**RESPONSE TO COMMENTS:**

**2/23/21**

**Permit Application Number: 2001-170**

**9027 SE 60th. St.  
Mercer Island, Wa. 98040**

Drawing Title:  
SITE PLAN

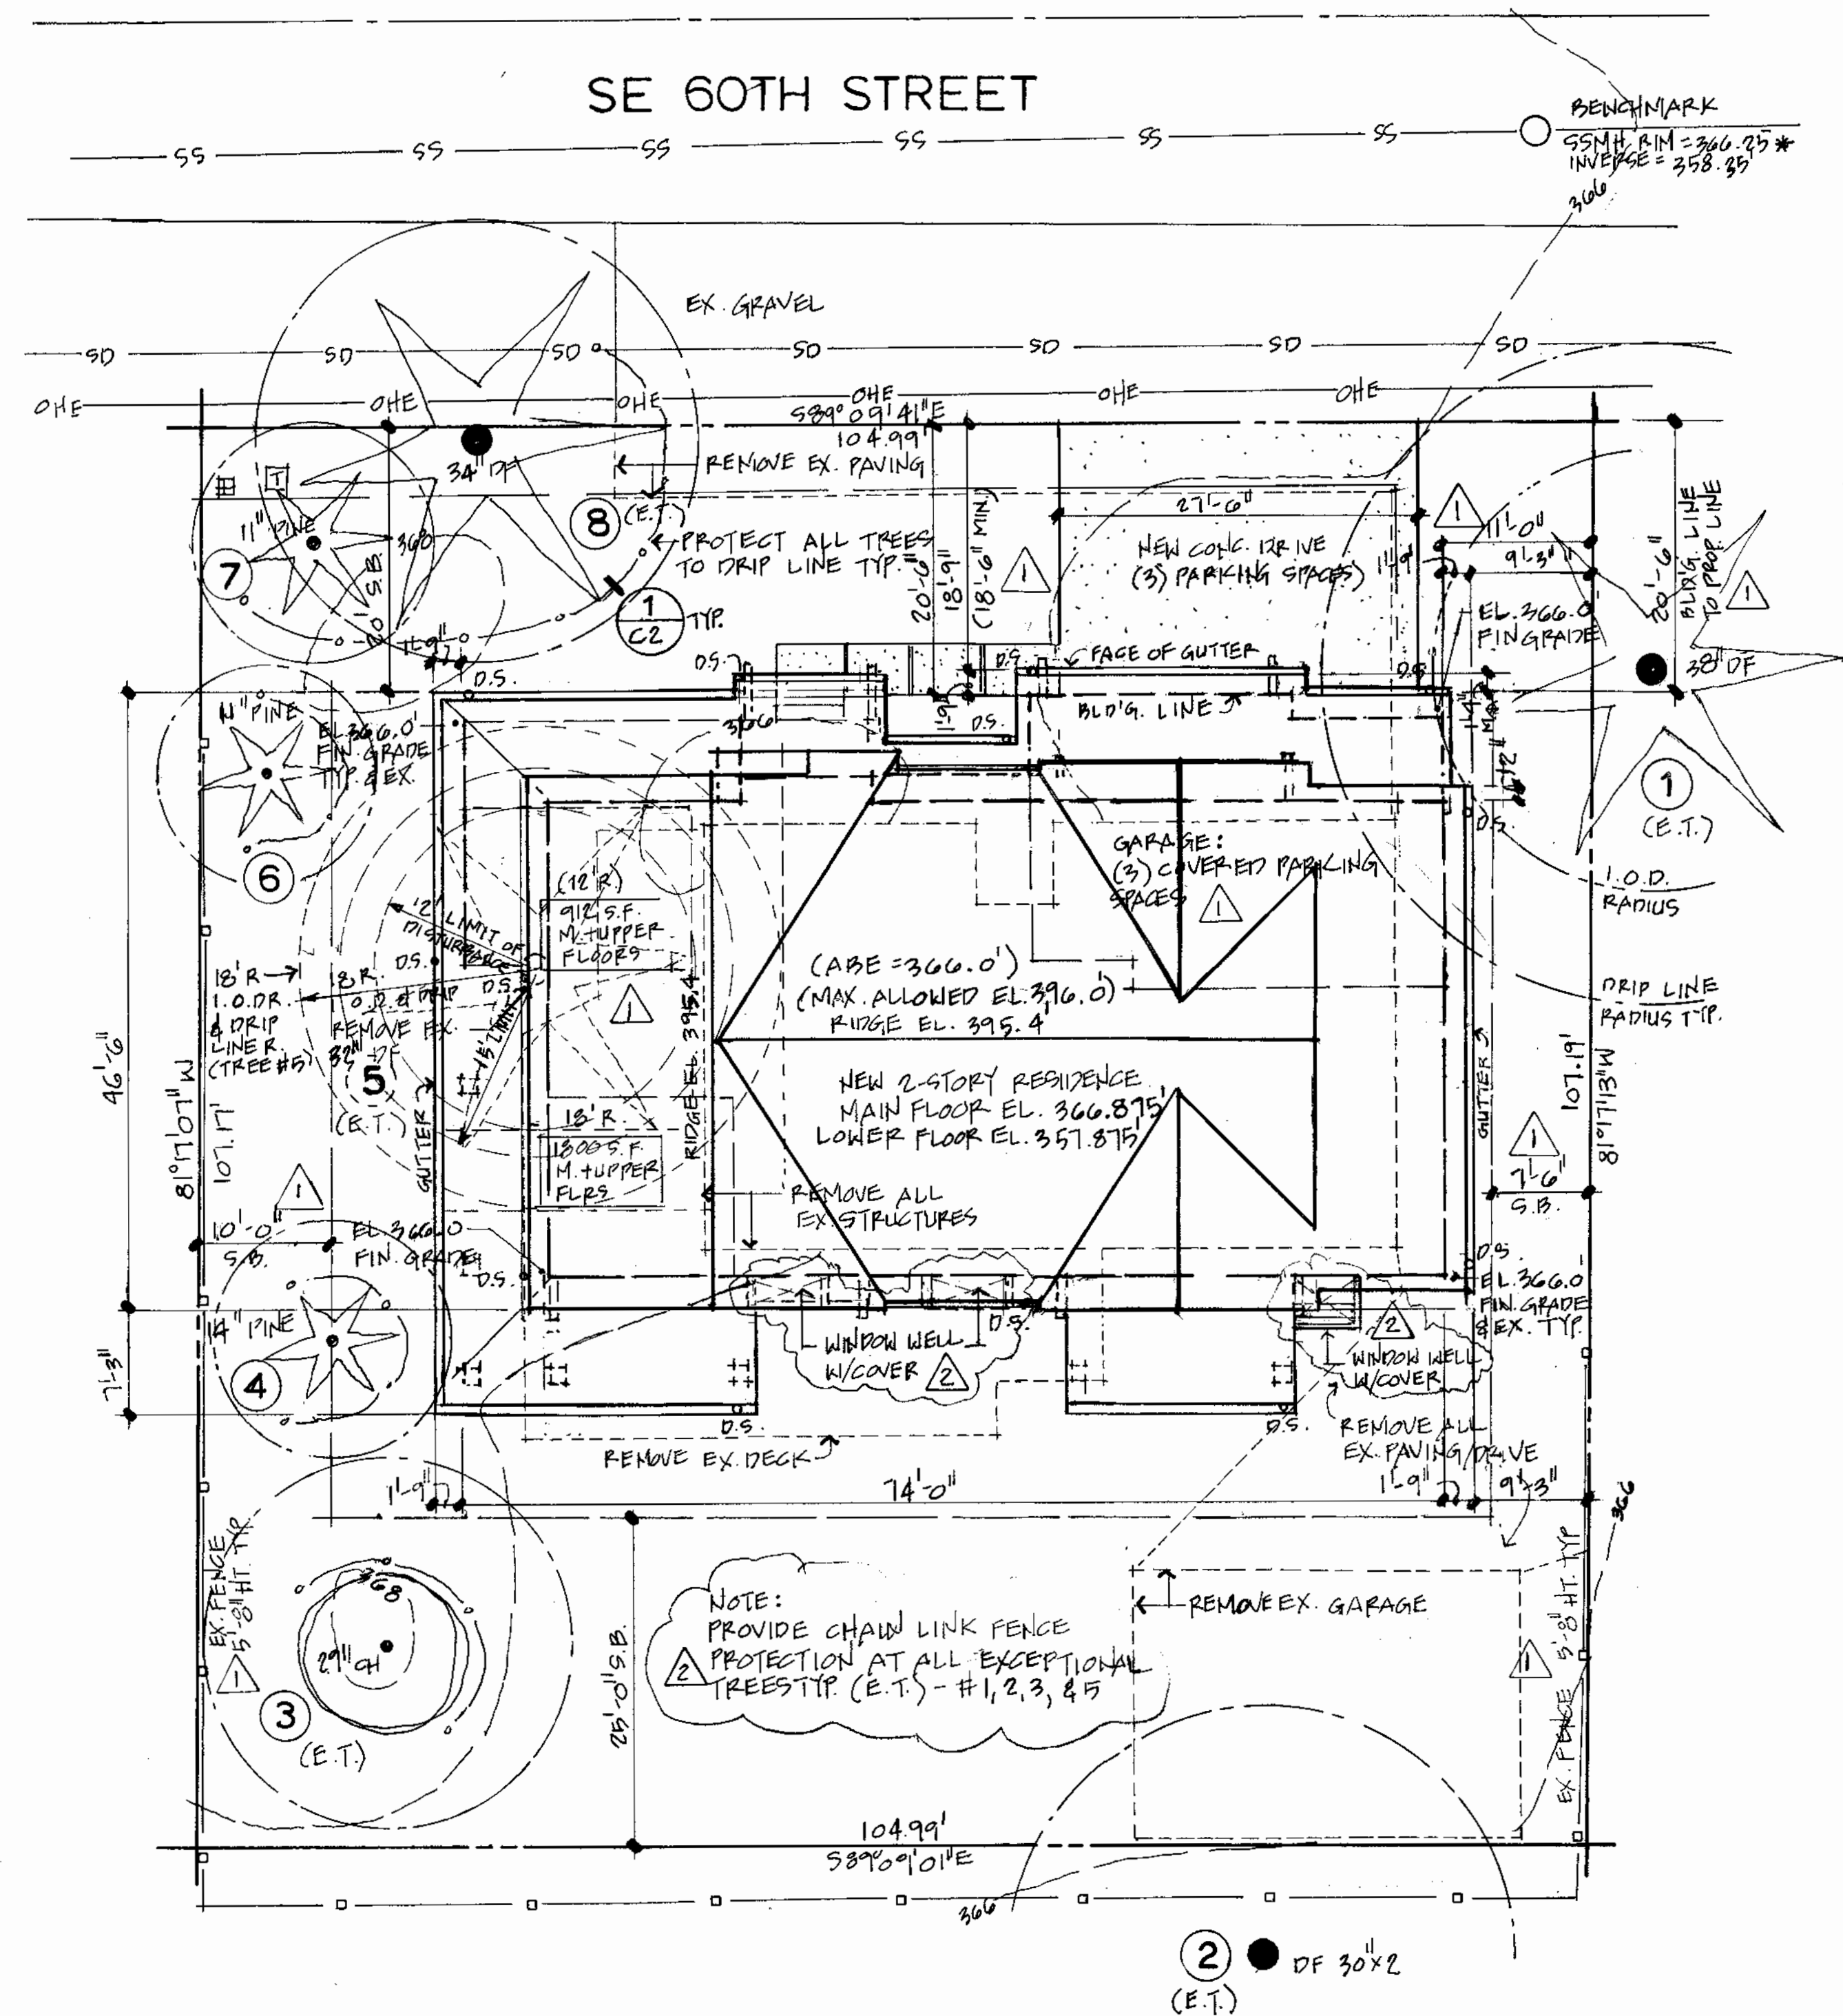
**Number 1: Added window wells to site plan sheet A1**

**Number 2: Located window wells on site plan A1 noted fall protection**

**FOUNDATION PLAN**  
SCALE 1/4" = 1'-0"

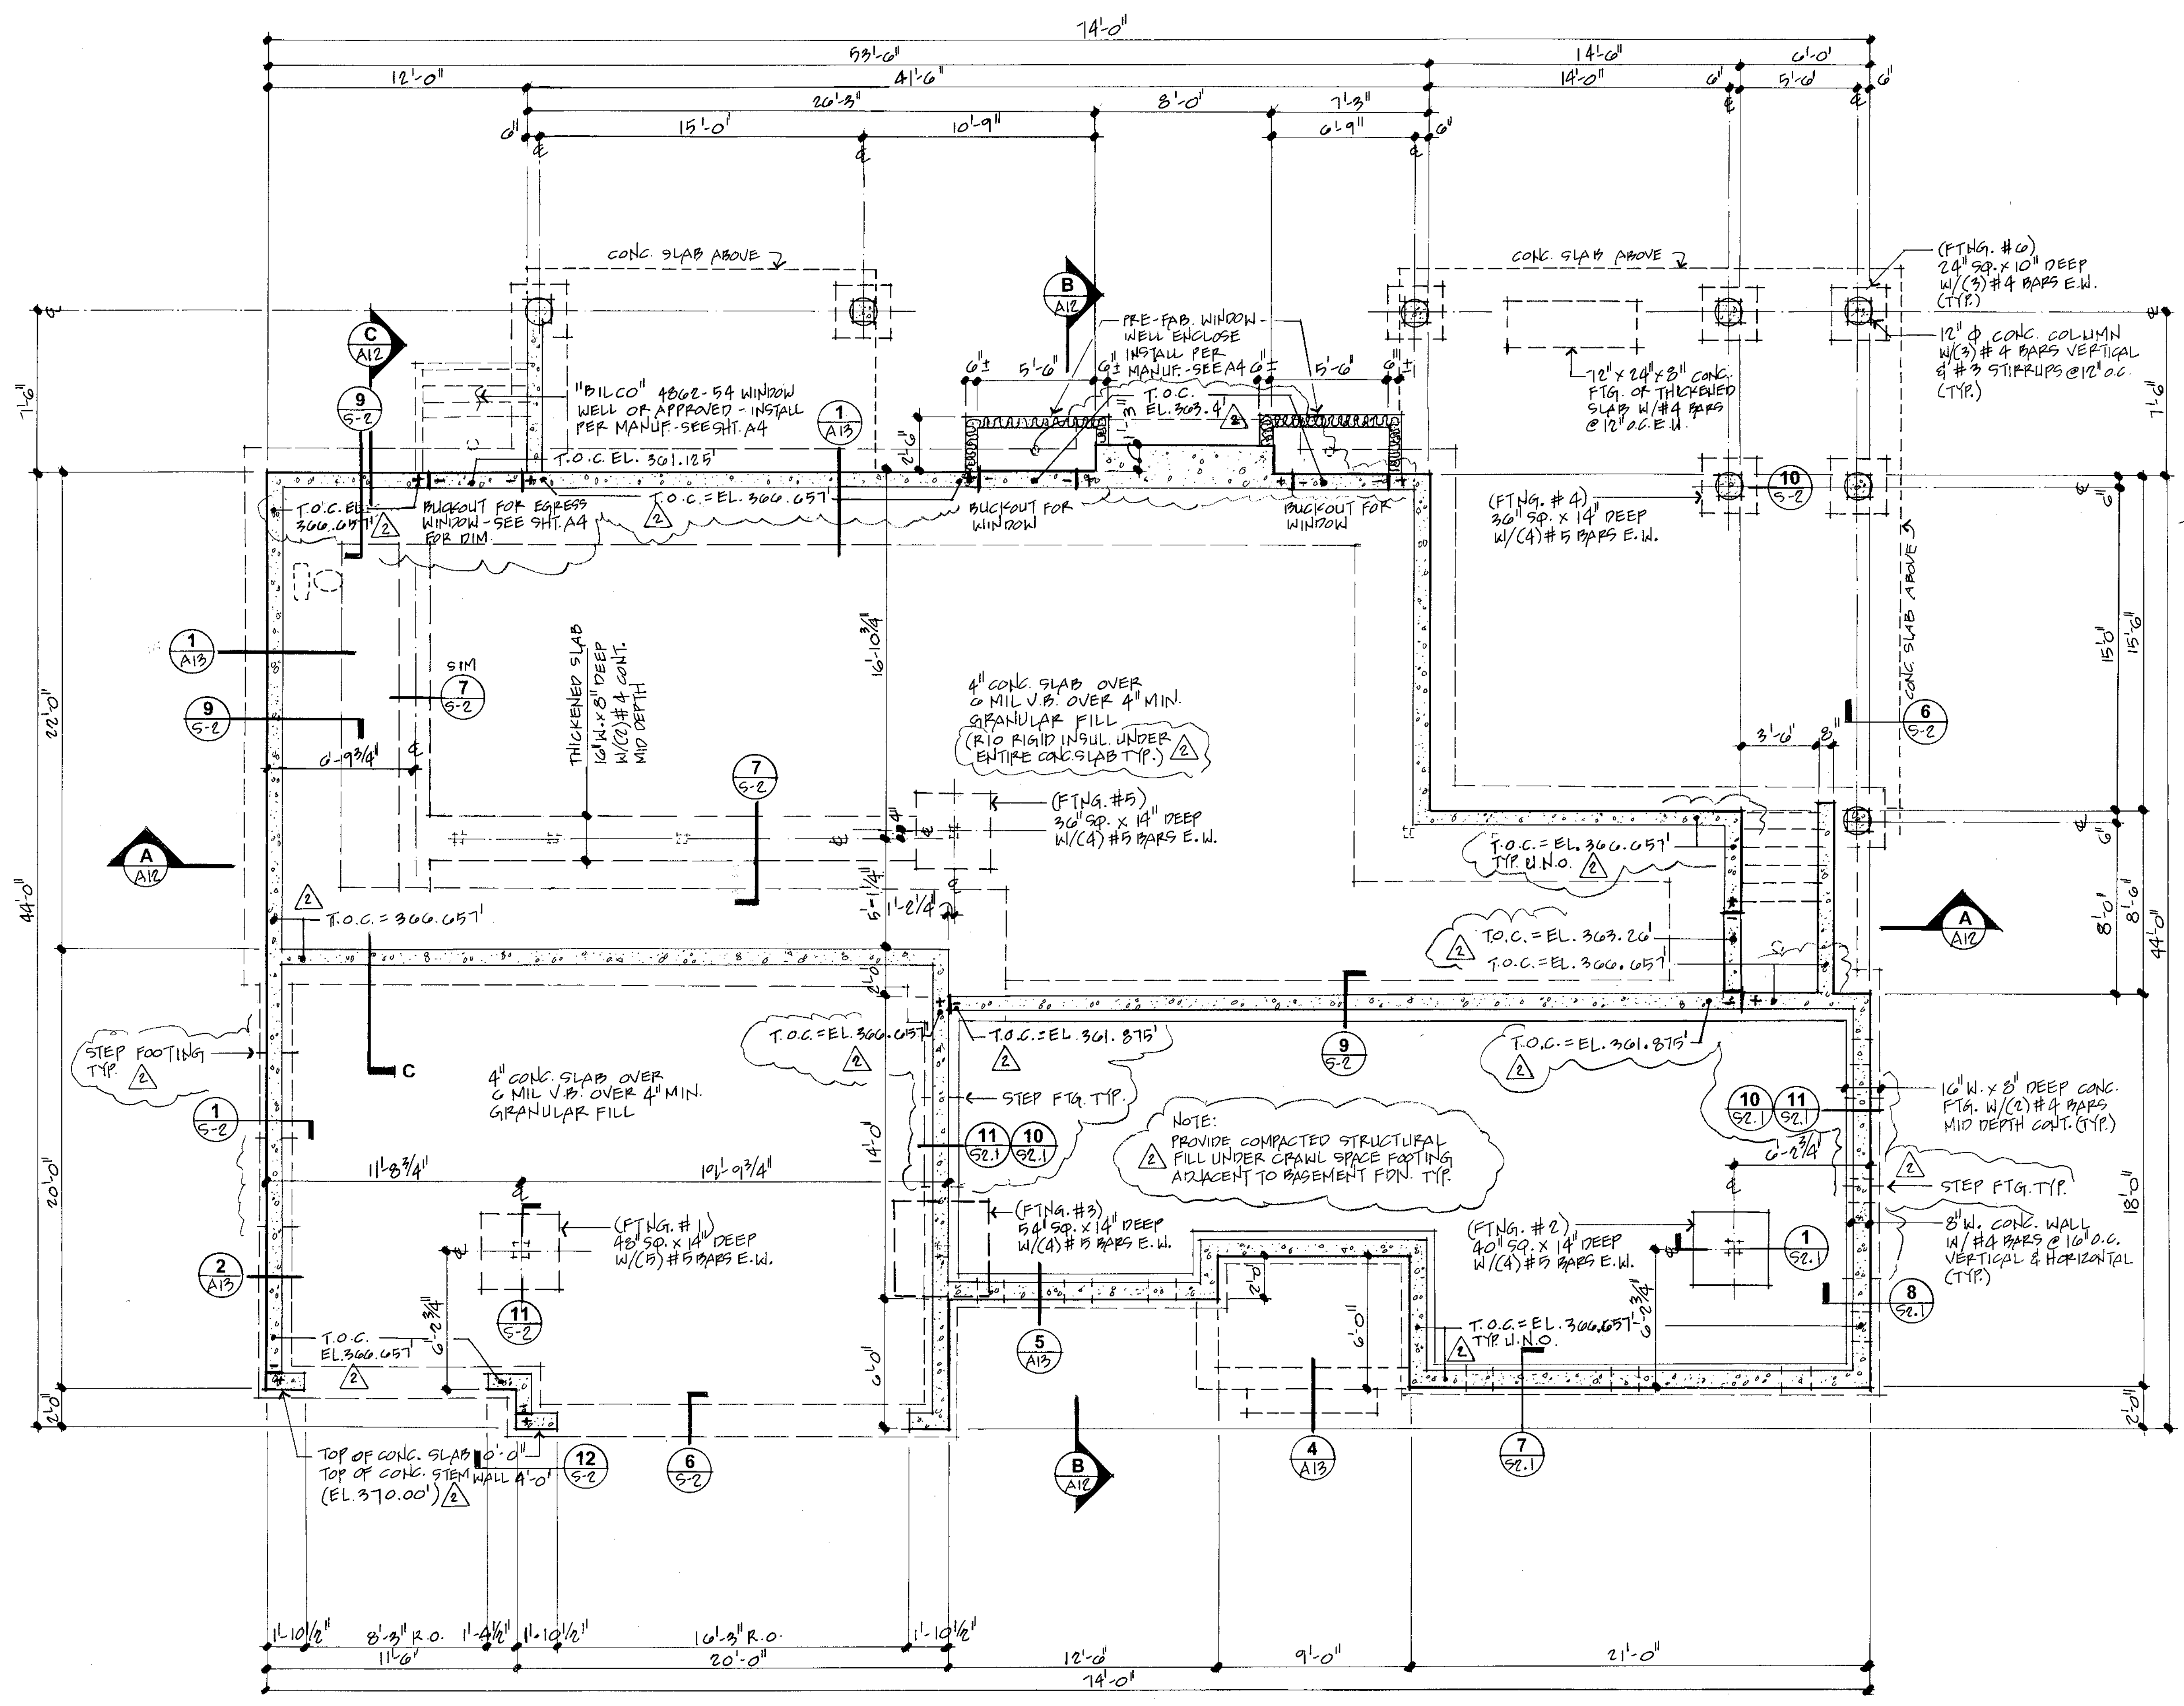
**Number 1: Noted top of concrete sheet A3**

**Number 2: Added step footing sheet A3**

**Number 3: Added notes sheet A3, see Structural sheet**

**A4**

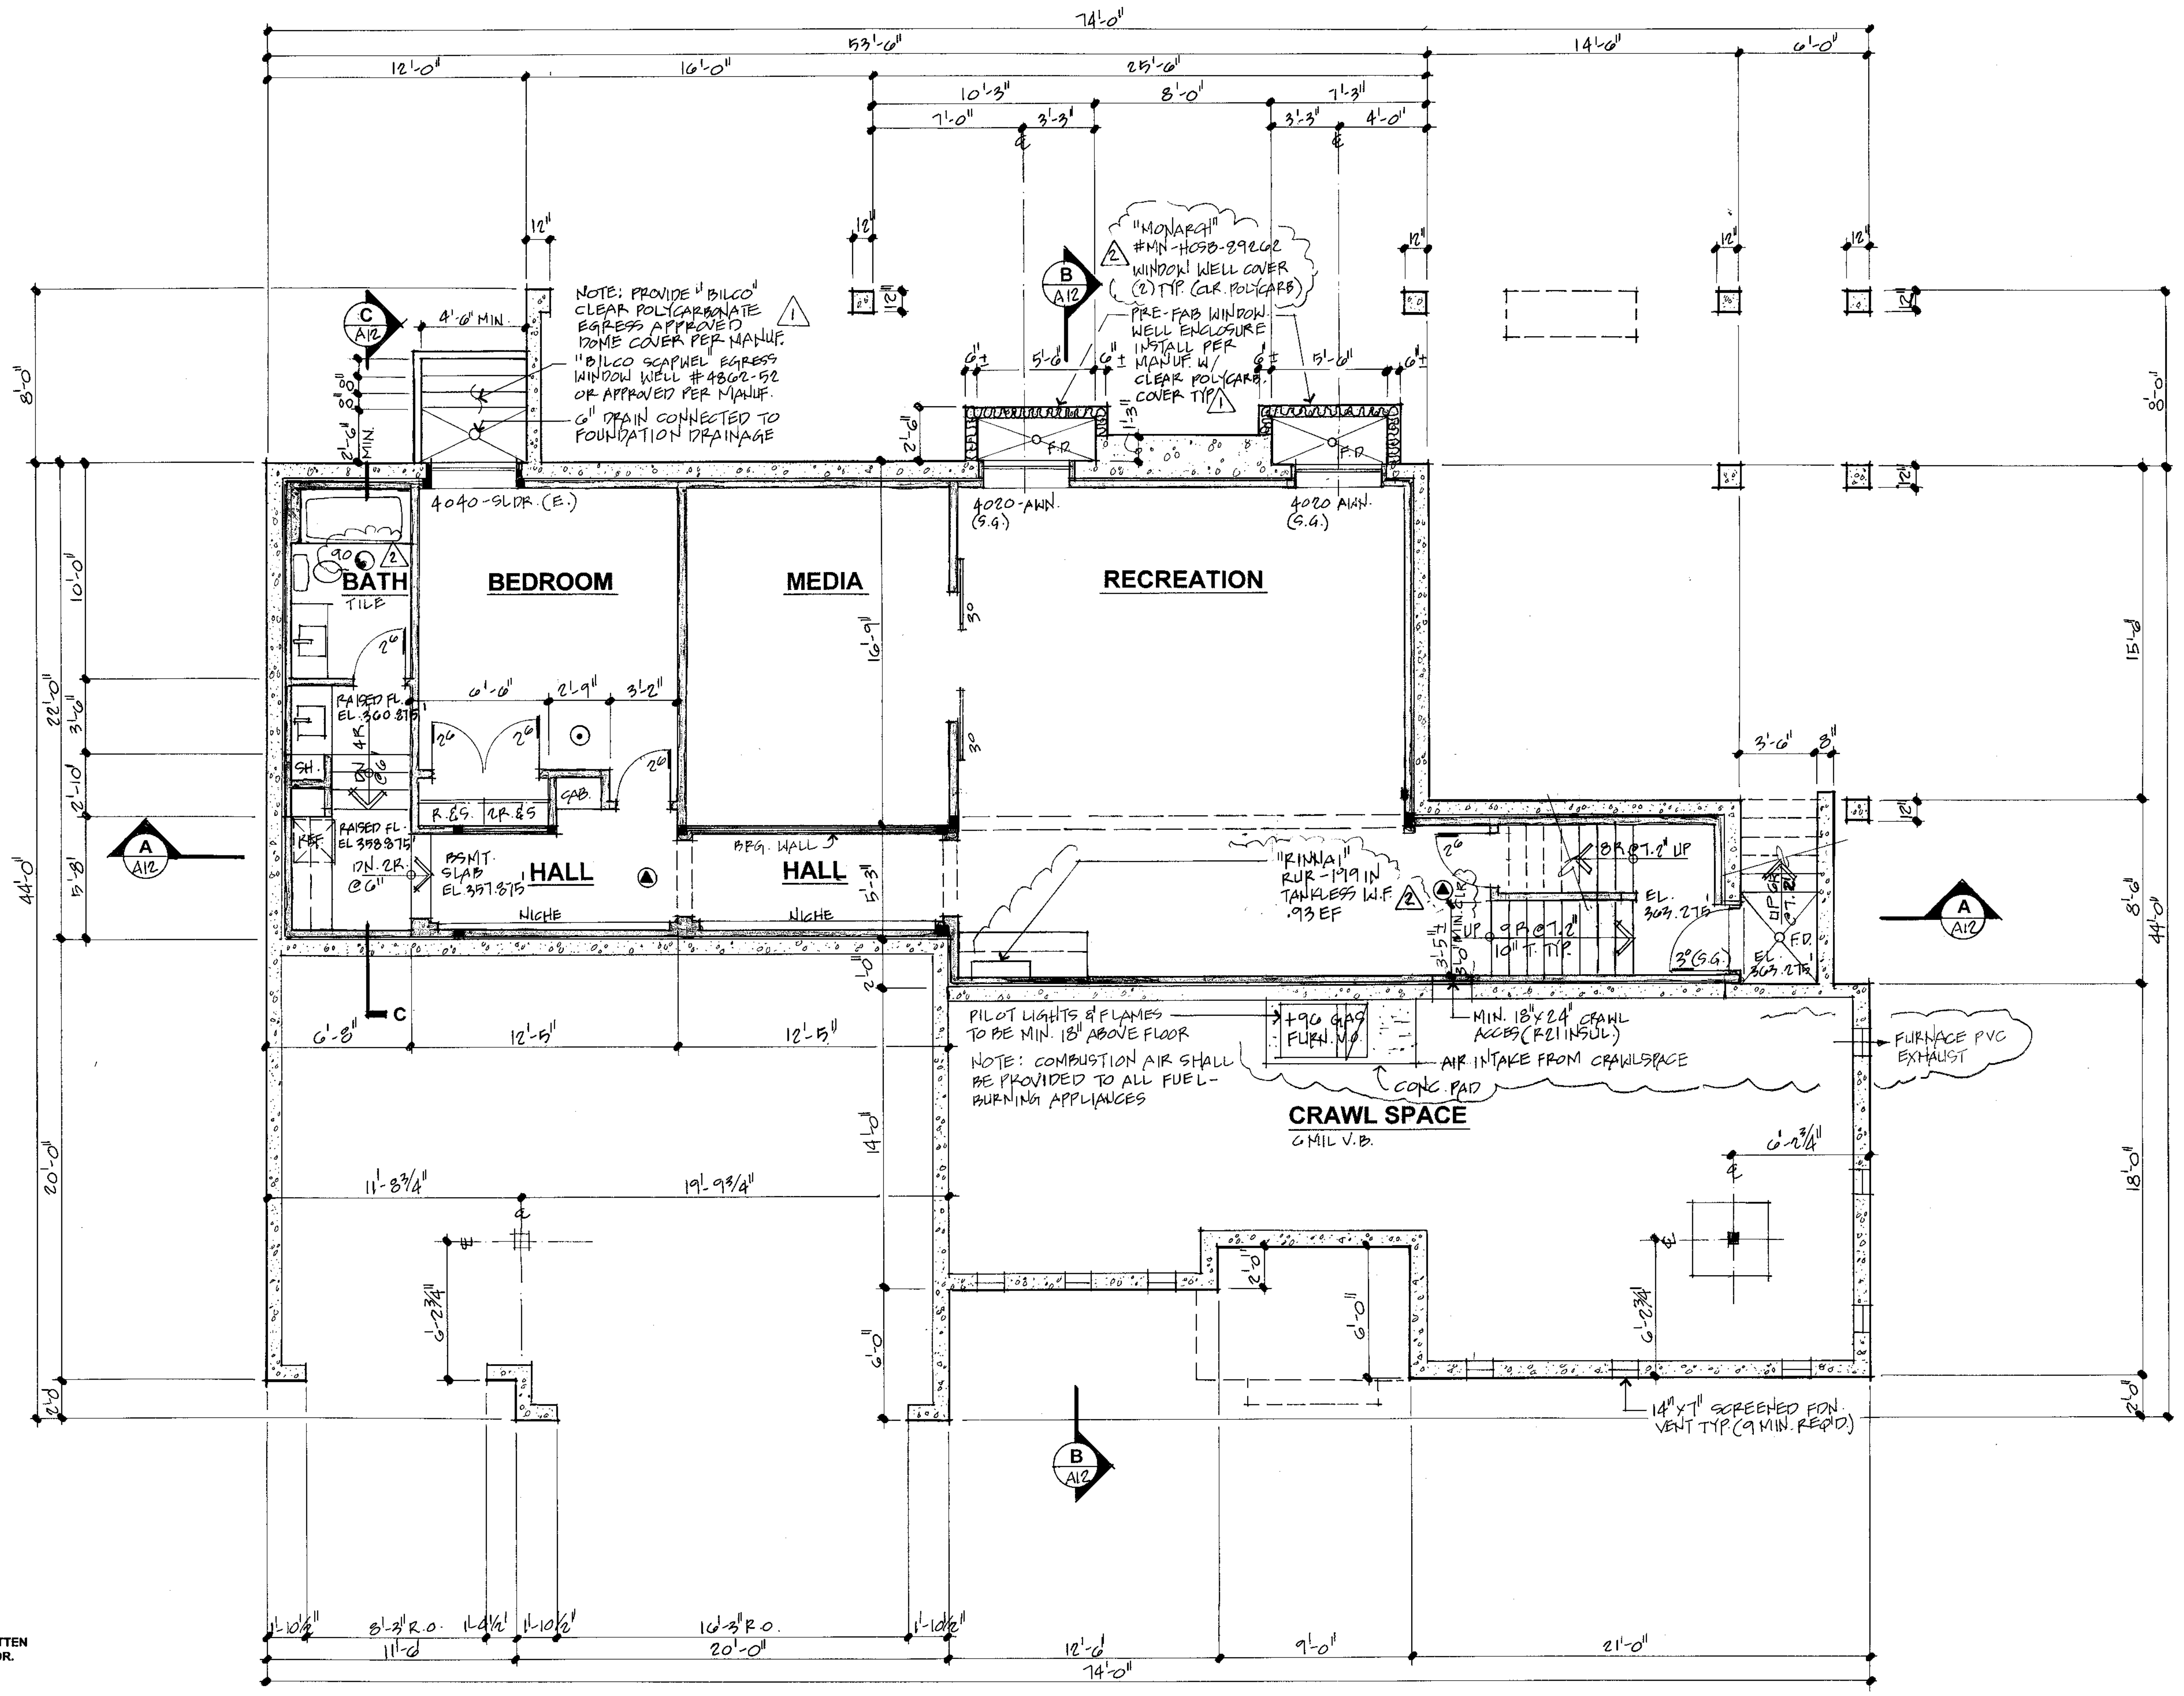
**Number 2: Added window well callouts on sheet A4**

**Number 3: Added efficiency callout on sheet A4**

**Number 4: Added fan/ventilation requirements sheet A4**

**Number 5: Added tread length sheet A4**
